**From:** Laura Gibbons <Laura.Gibbons@arun.gov.uk>  
**Sent:** 27 July 2021 12:04  
**To:** Planning.Responses <Planning.Responses@arun.gov.uk>  
**Cc:** Michael Eastham <Michael.Eastham@arun.gov.uk>  
**Subject:** RE: Planning Consultation on: BE/110/21/DOC

**Application No:** BE/110/21/DOC

**Site Address:** Land At Salt Box West Of Shripney Road Bognor Regis PO22 9NW

**Description of Works:** Approval of details reserved by condition imposed under hybrid application BE/135/18/PL relating to Full Condition Nos 4 - external lighting, 7 - vehicular access link, 8 - car park & covered and secure cycle parking, 10 - hard & soft landscaping, 12 - surface water drainage, 13 - discharge flows to watercourses, 14 - maintenance & management of surface water drainage, 15 as-built drawings of the implemented scheme, 16 - foul drainage, 21 - CCTV strategy (Units 4-9), 23 footpath connections, 30 security fencing (Units 6,7,8 & 9), and 45 - levels.

HYDROCK PROJECT NO. C-13319-C		SCALE @ A1 1:250
STATUS DESCRIPTION CONSTRUCTION		STATUS A1
DRAWING NO. (PROJECT CODE-ORIGINATOR-ZONE-LEVEL-TYPE-ROLE-NUMBER) SAL-HYD-PH1-ZZ-DR-C-7021		REVISION C07

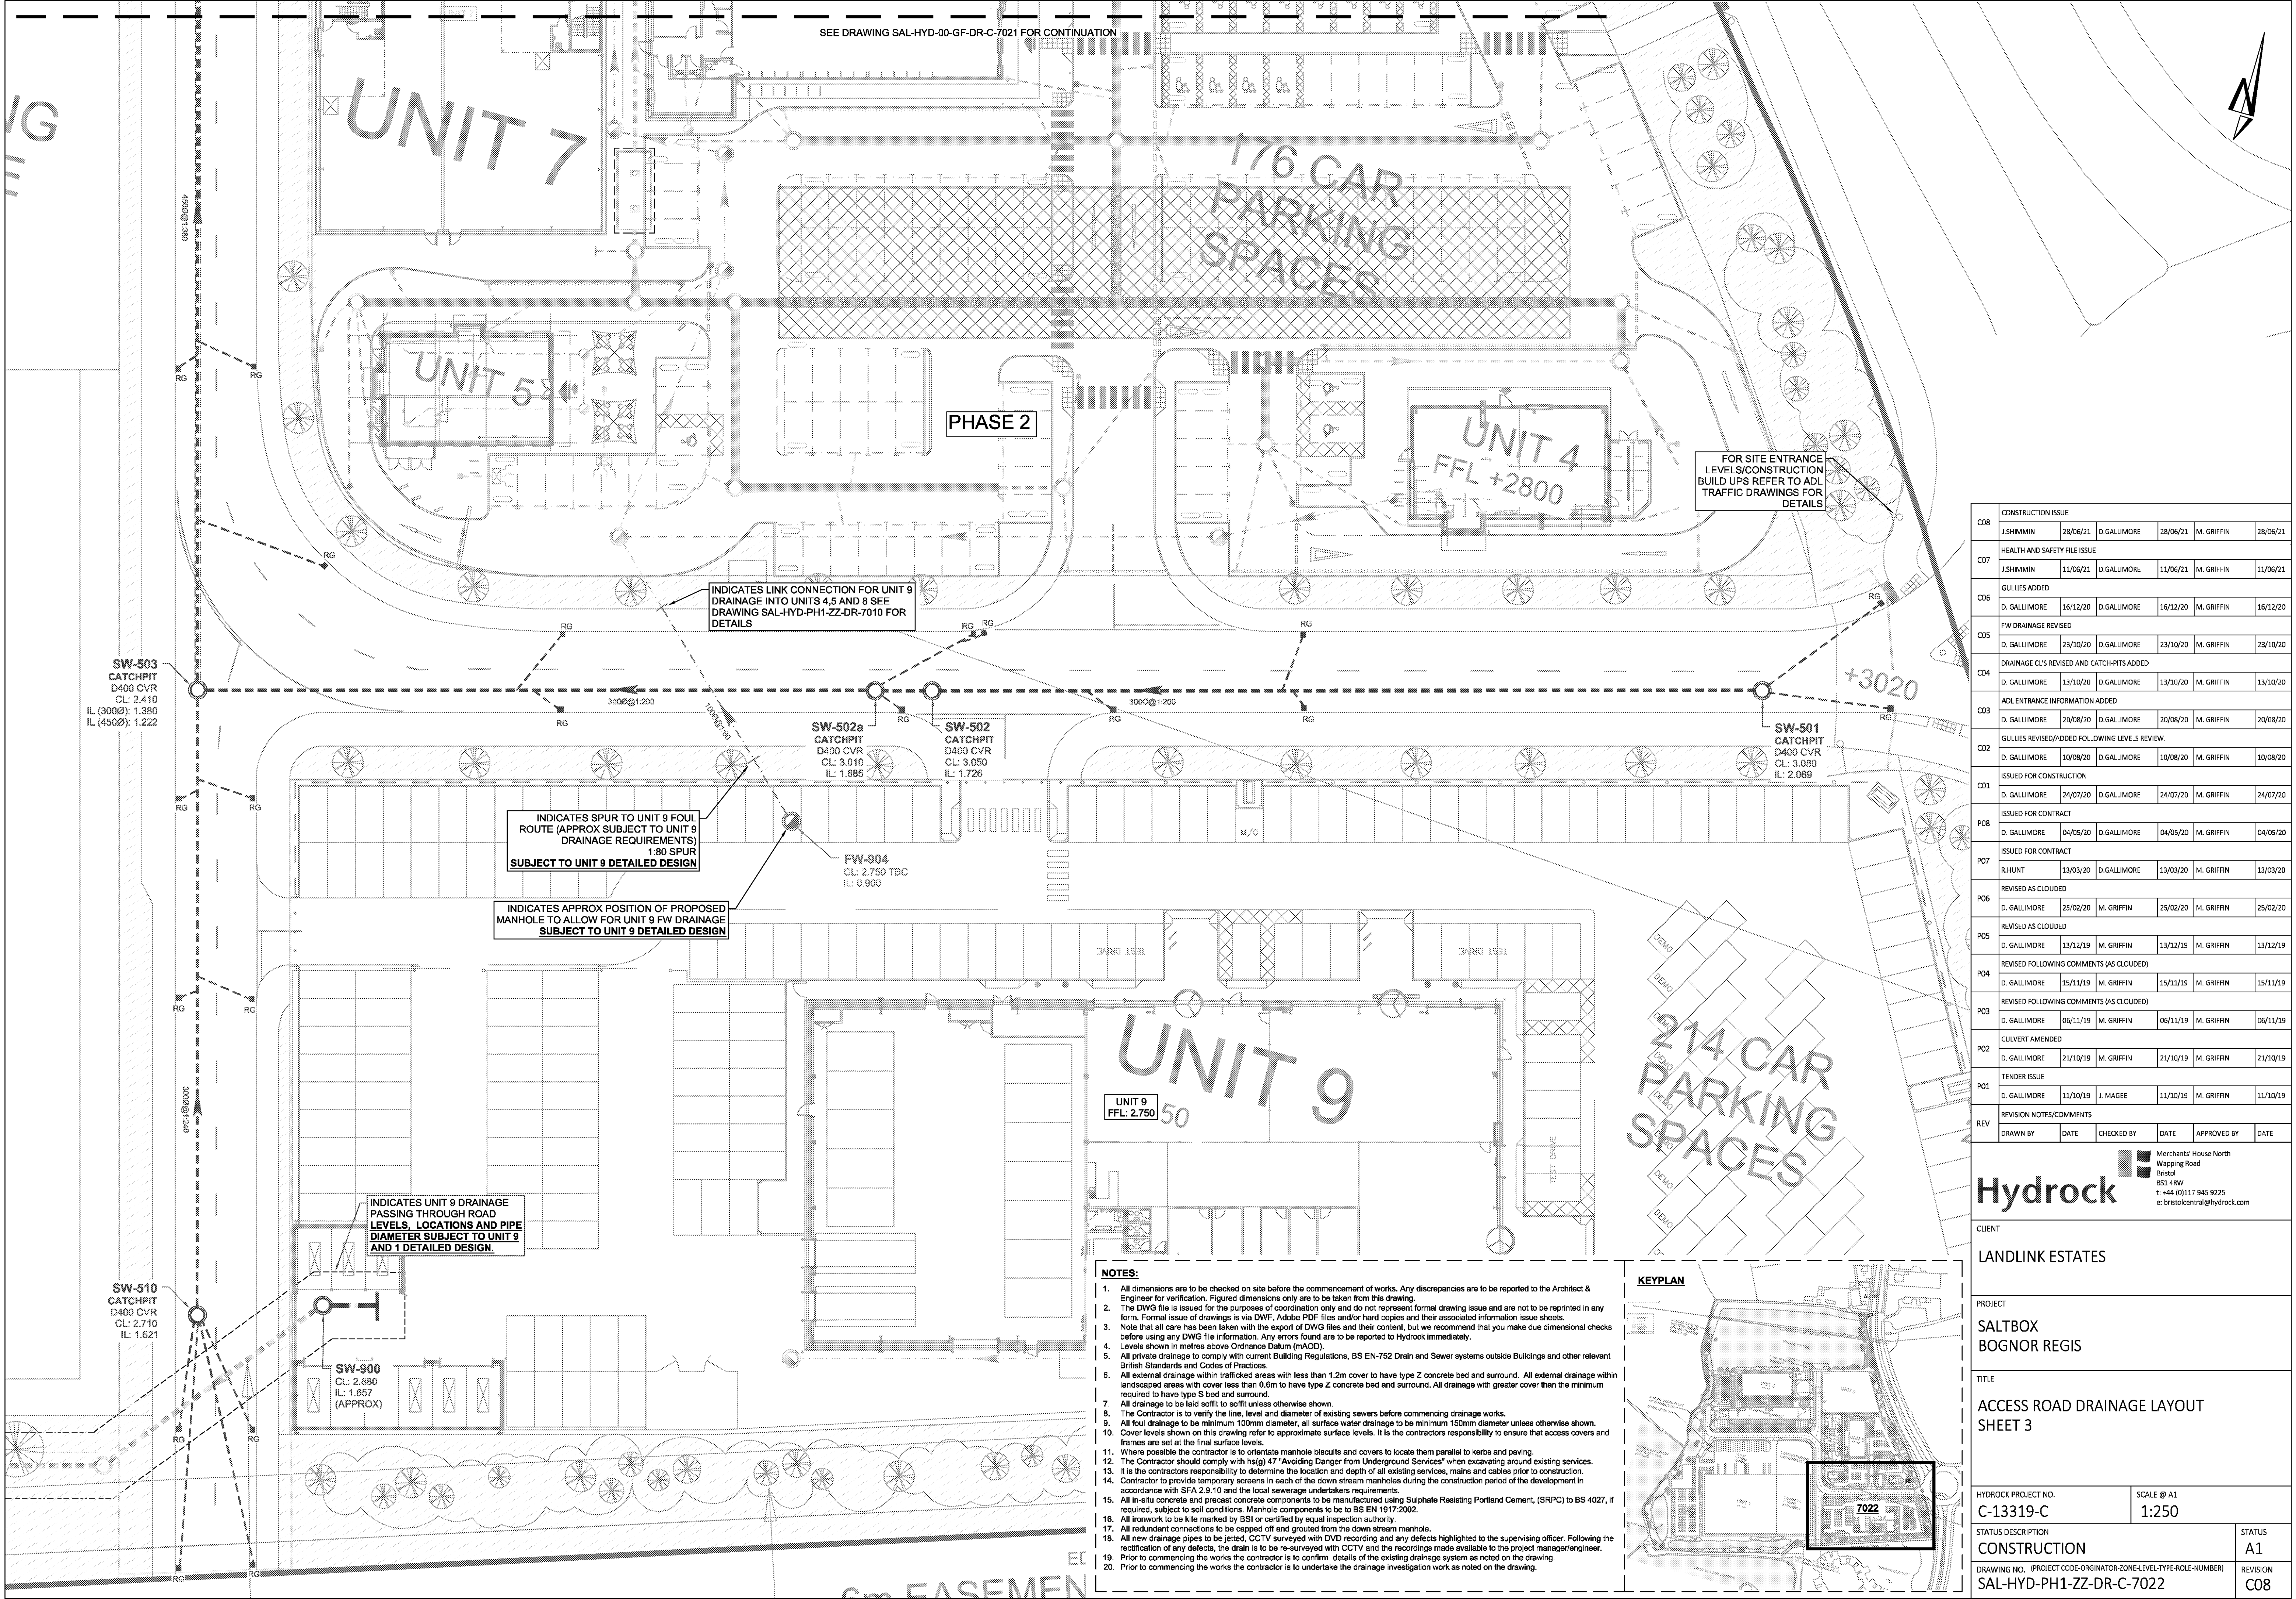
It is unclear what changes are proposed here under conditions 12, 13 and 14. You advised that this application is regarding the kerb and junction changes to unit 3. Yet it is clear that several revisions of the drainage drawings have occurred since we were last involved. For example SAL-HYD-PH1-ZZ-DR-C-7021-P11 was listed as approved under BE/21/20/DOC, yet under this application we have revision C07, which is 7 revisions later. As this is the case it is likely that we will need to complete a full review.
